From: [REDACTED]
To: [Hinckley SRFI](#)
Subject: Hinckley RNFI - Objection
Date: 03 February 2025 10:35:54

Following on from the latest amendment to the proposal please see below as to why I strongly object and feel that critical details have been overlooked.

Proposed Layout - 16.5m Max Legal Articulated Vehicle

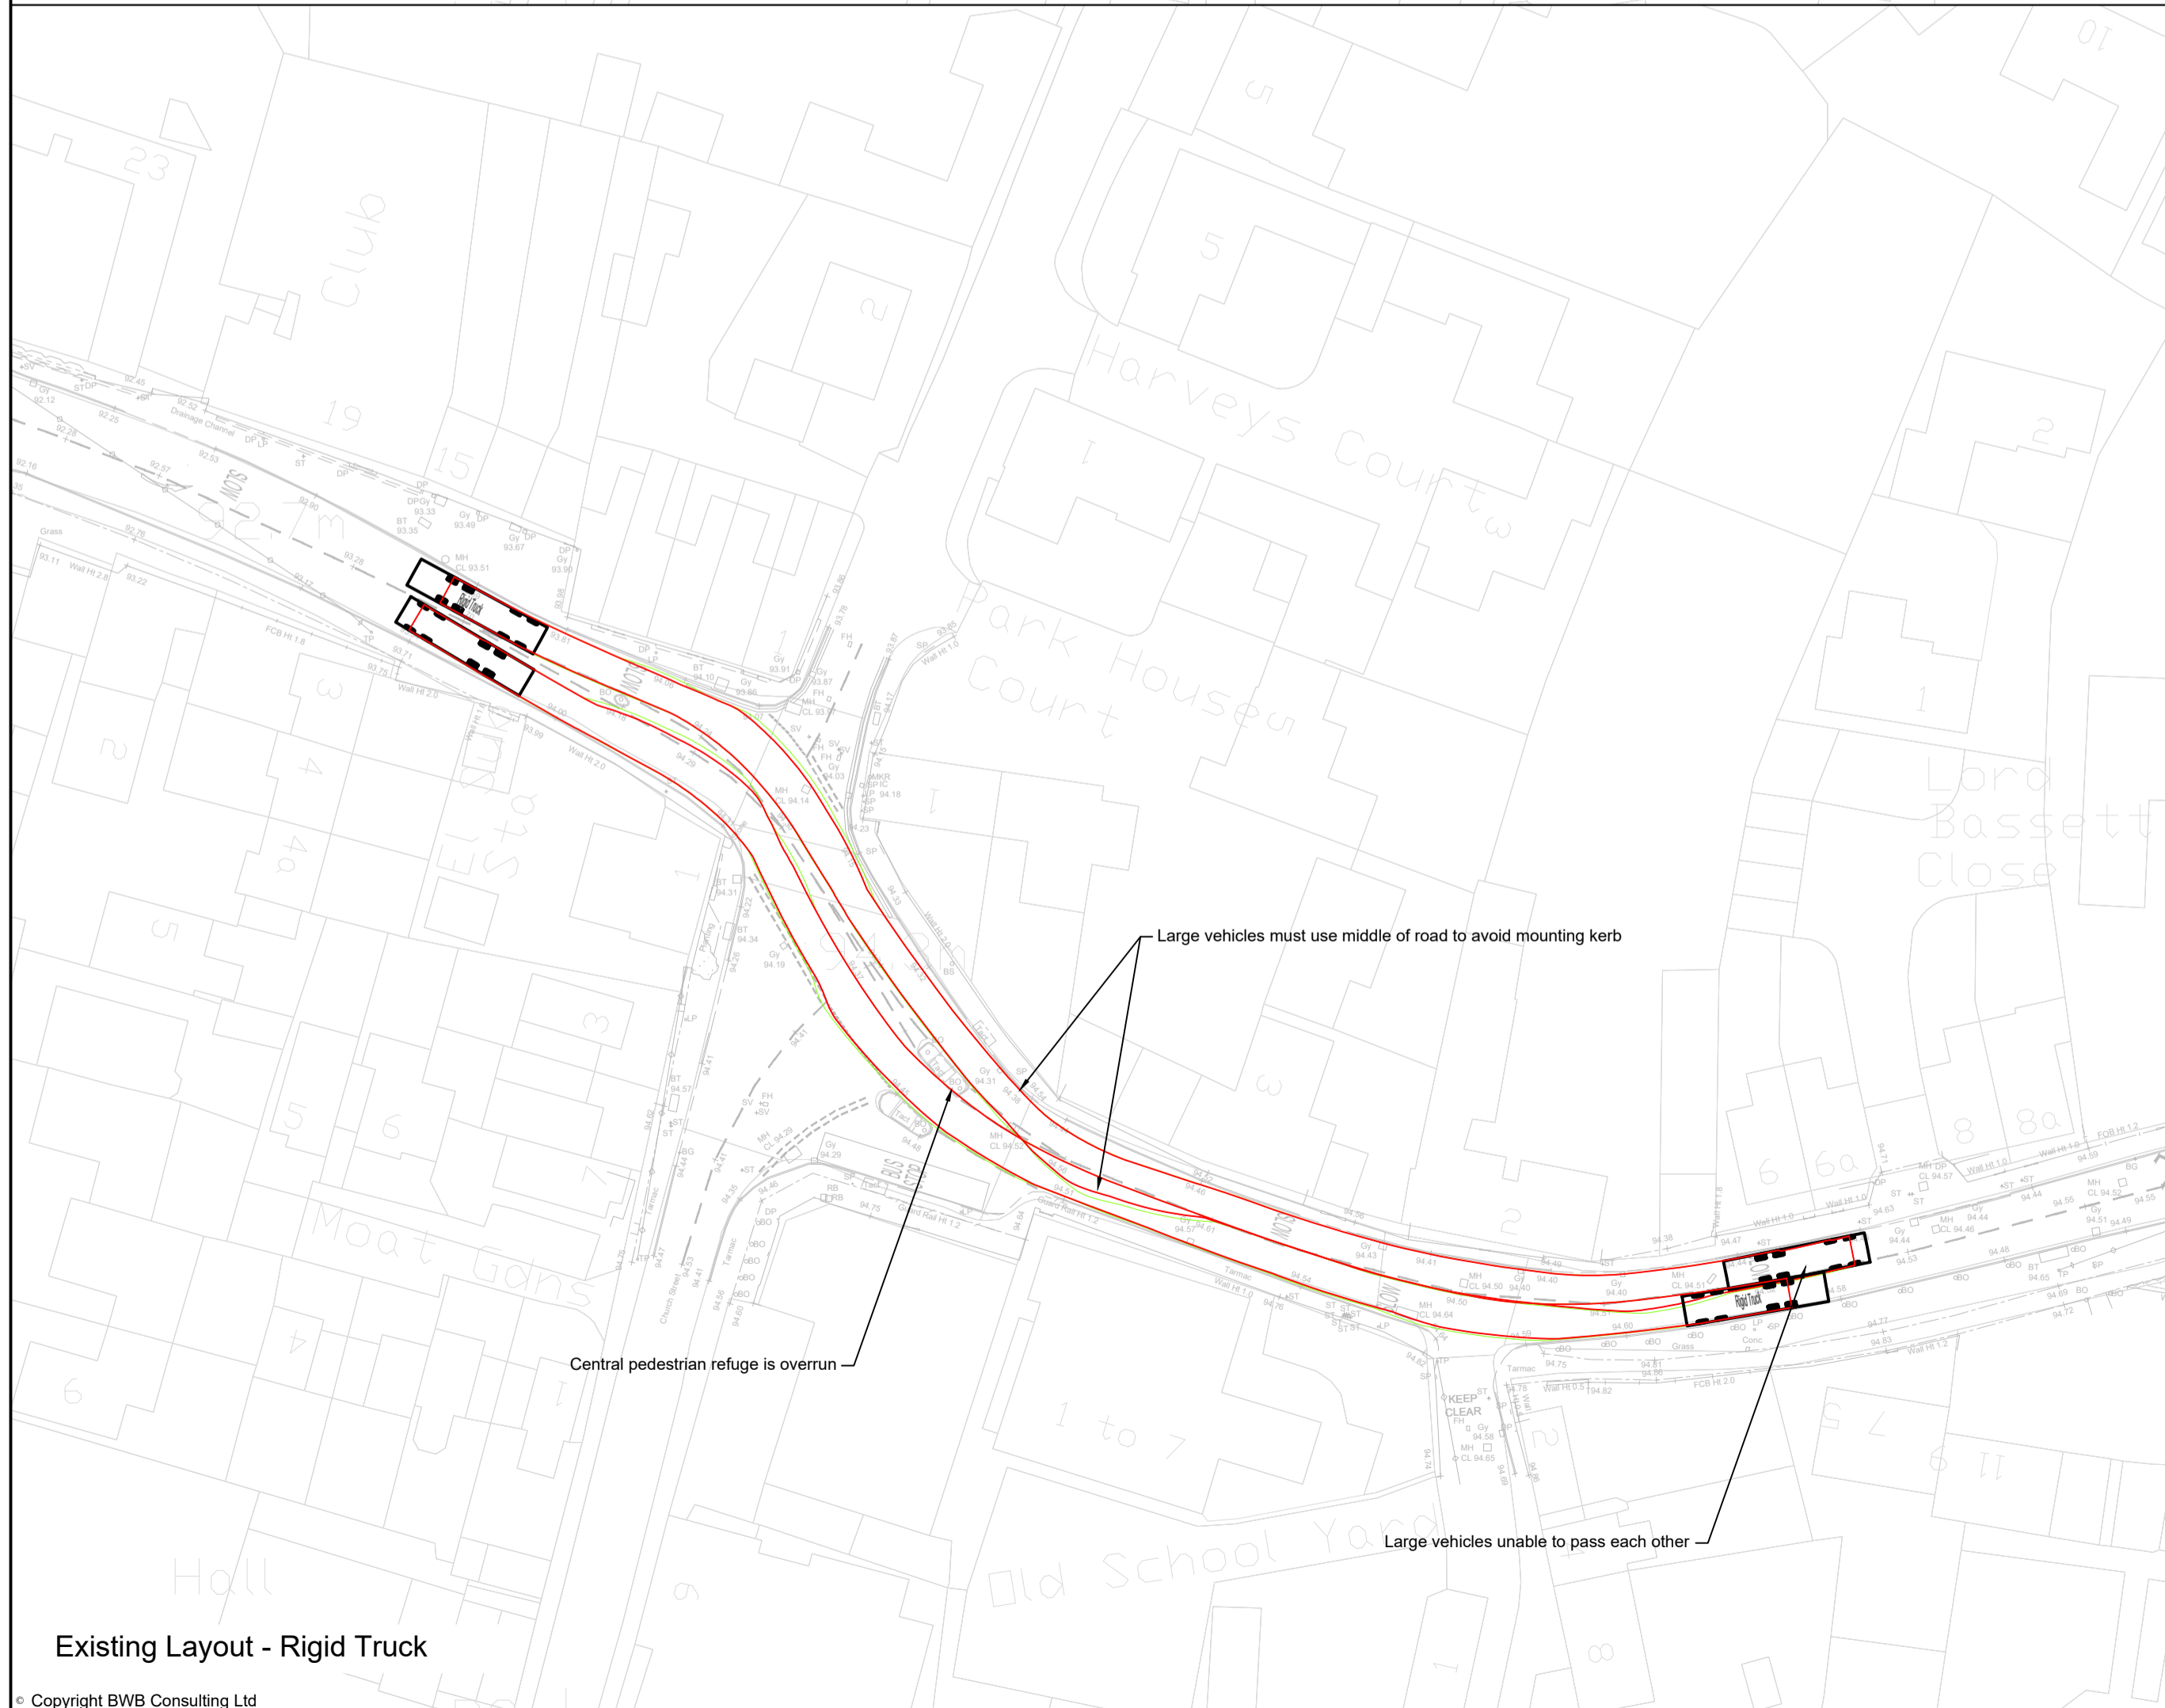
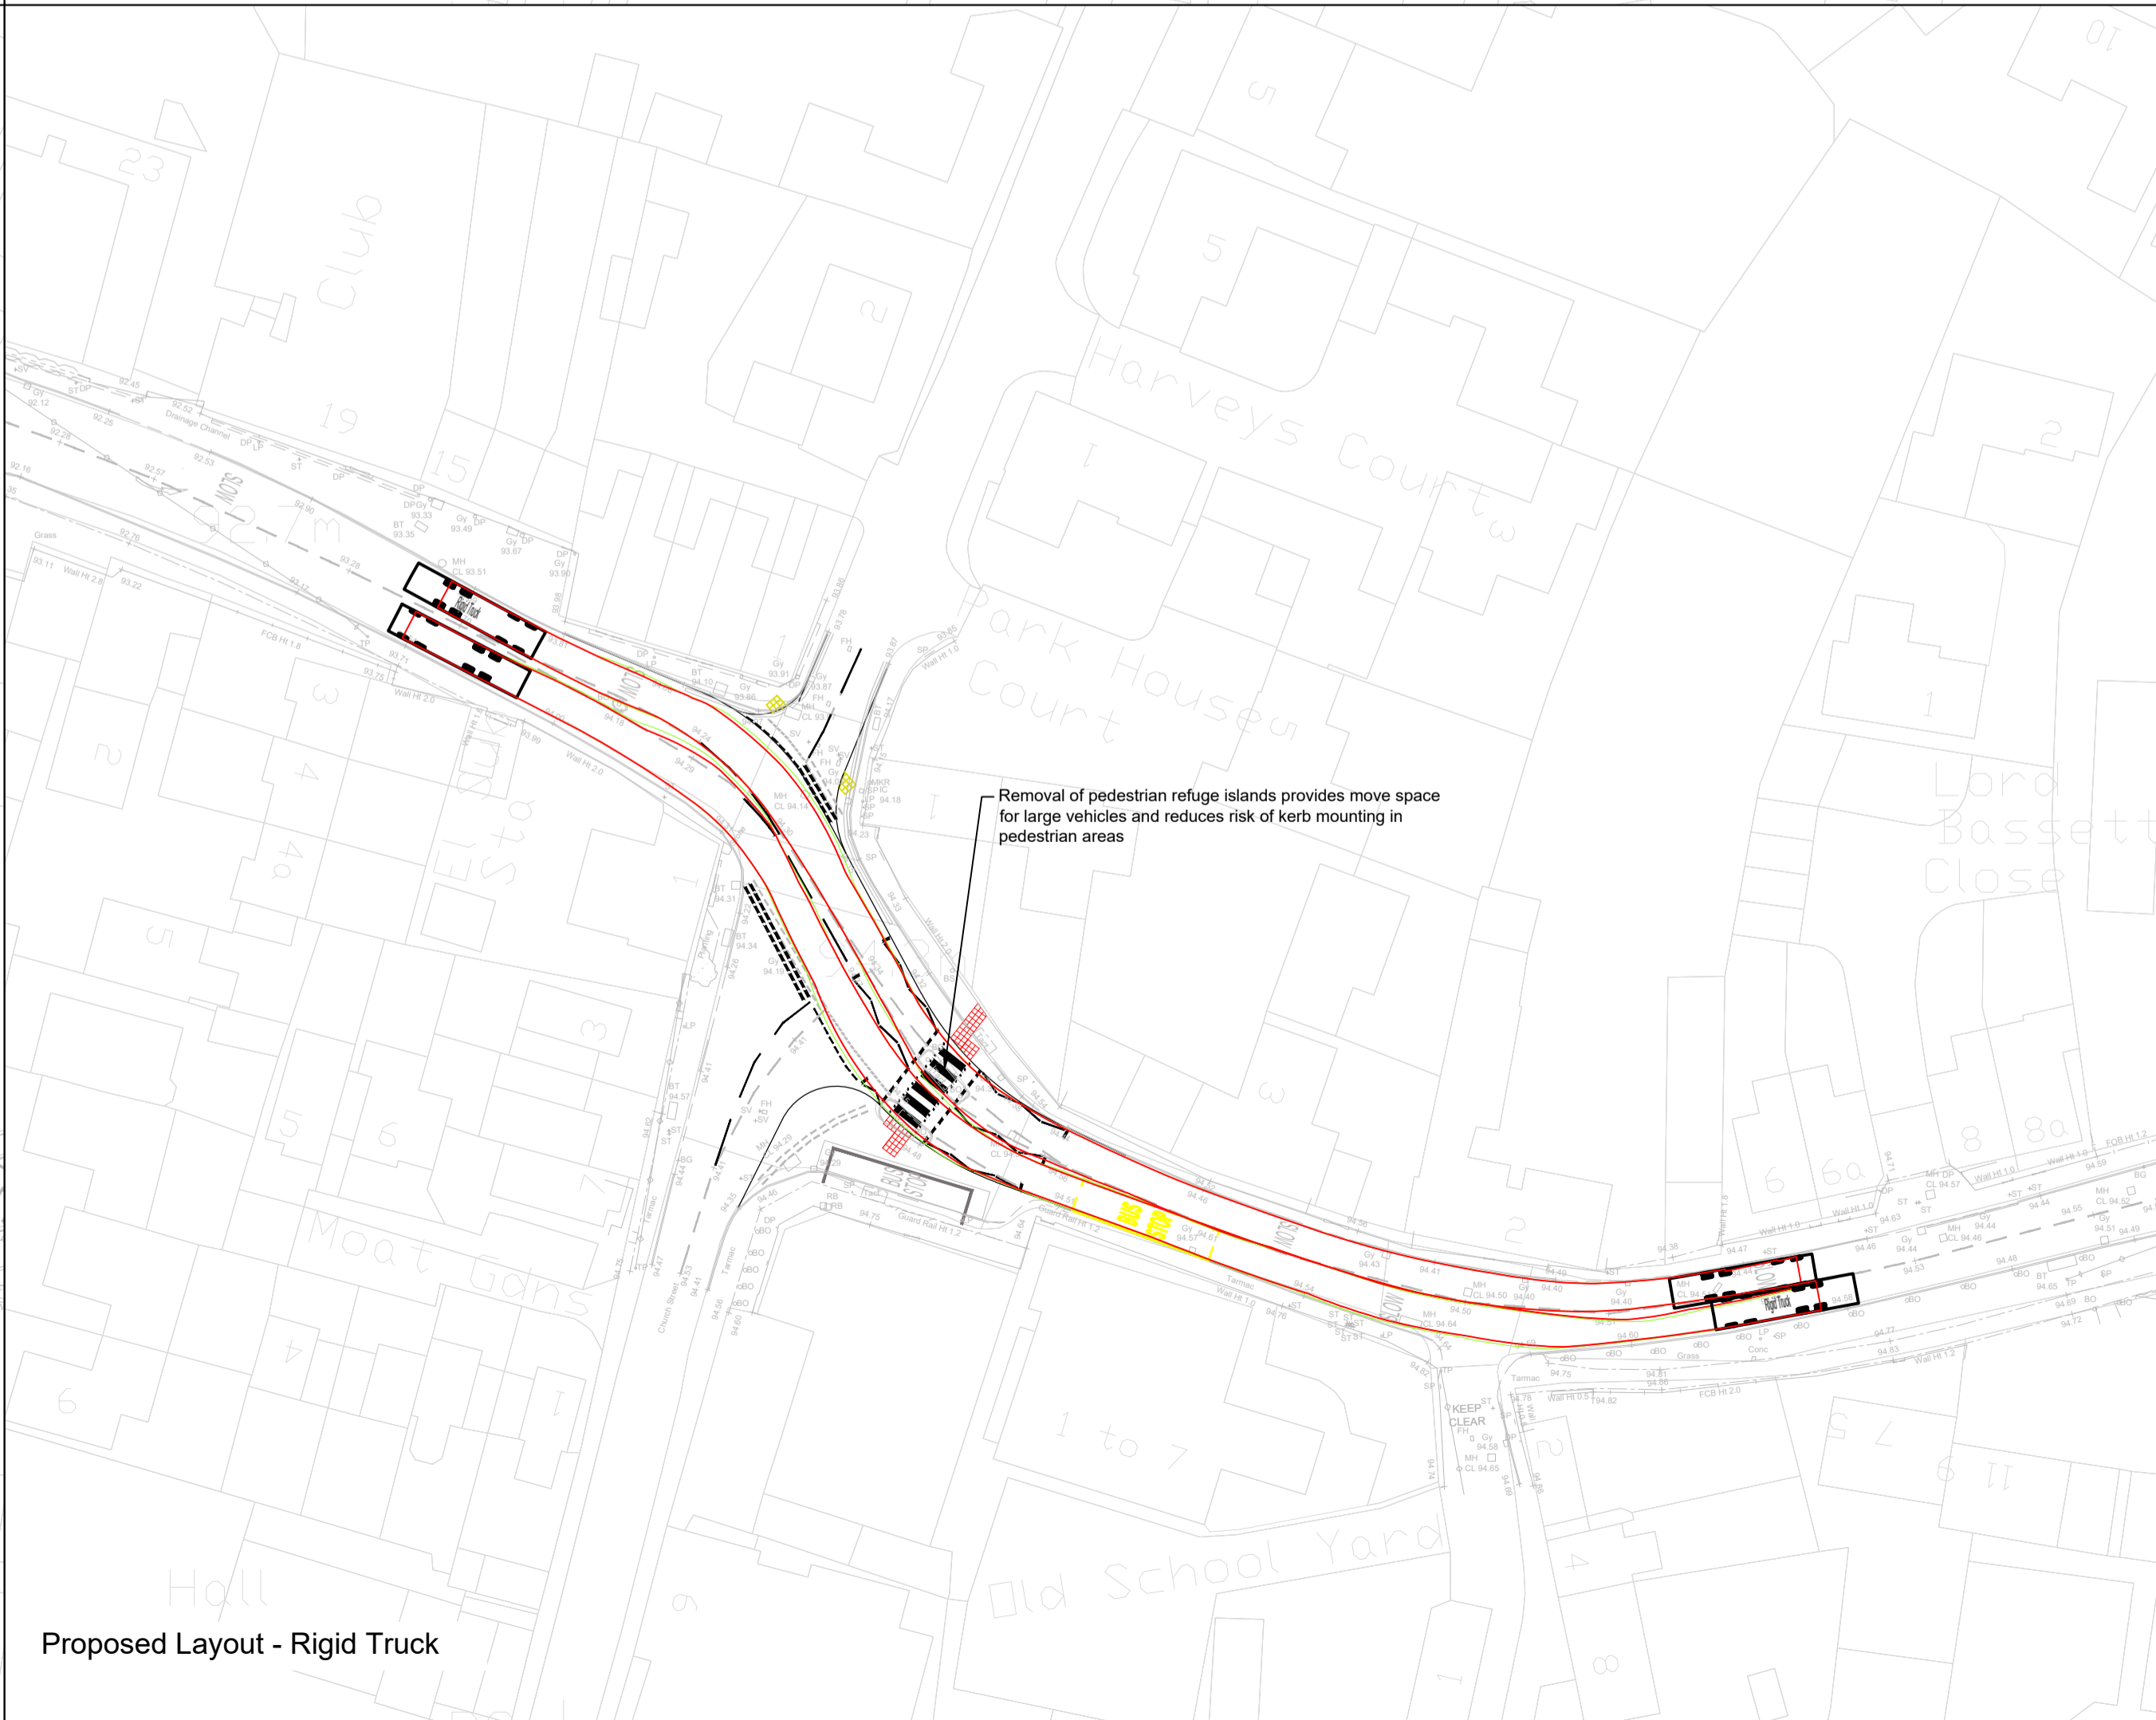
The suggestion of a narrow road to reduce the amount of HGVs passing through the village is bizarre. What stops either vehicle? There is no provision for this? What if there is already a school bus making it's way through? What if there is village traffic already making it's way through? What if a farm tractor is already making it's way through? No consideration has been given to delivery vehicles, removal vehicles, refuse lorries, school buses which may already be using any of the other roads in the village and need to make use of the suggested narrow road.

There is no provision made for vehicles parked on the side of the road (entirely legally) outside of the nursery, or the properties on Leicester Road?
